From: Liz Chippendale <Liz.Chippendale@kirklees.gov.uk>
Sent: 10 April 2025 15:49
To:
Subject: 2024/91242 - Shepley Road, Stocksmoor

Kirklees Highways DM have now reviewed the latest information provided, including the proposed improvements to Stone Wood Lane.

Title
 STONE WOOD LANE
 FEASIBILITY LAYOUT
 HIGHWAY IMPROVEMENTS
 SHEET 1

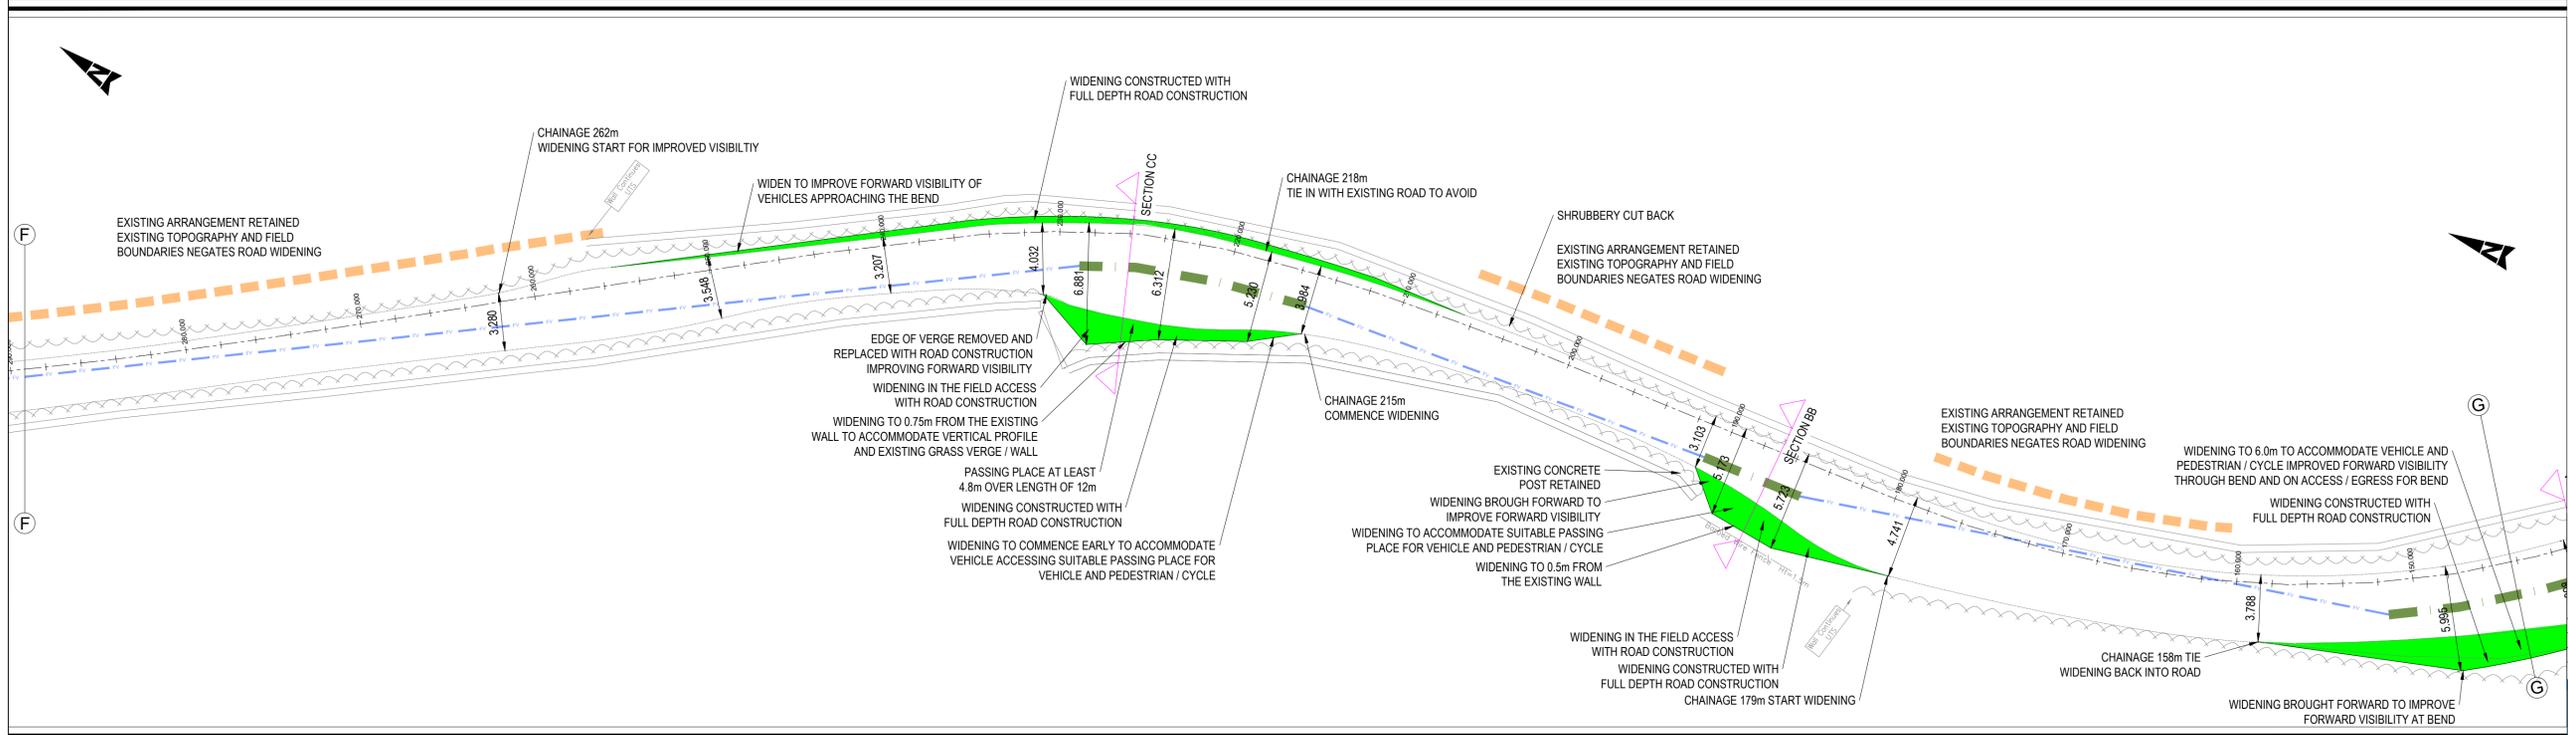
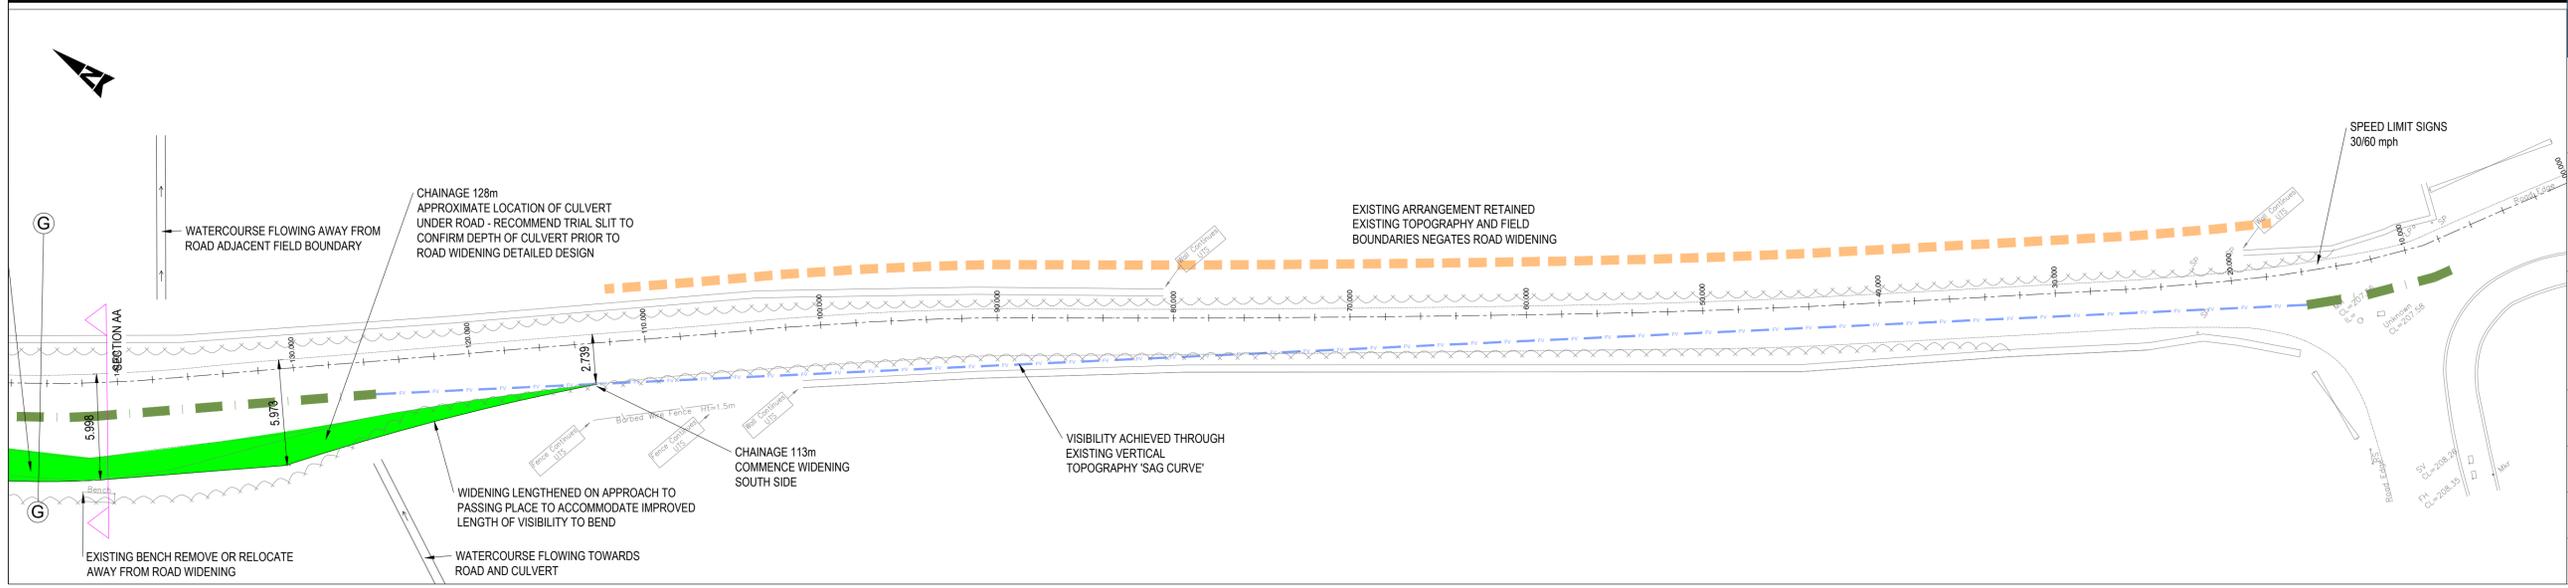
Whilst there is a clear effort to try to offer passing bay improvements, the highway boundary constraints do not allow for improvements to a level that would be expected to overcome the concerns. Therefore, Kirklees Highways DM are unable to support the proposals.
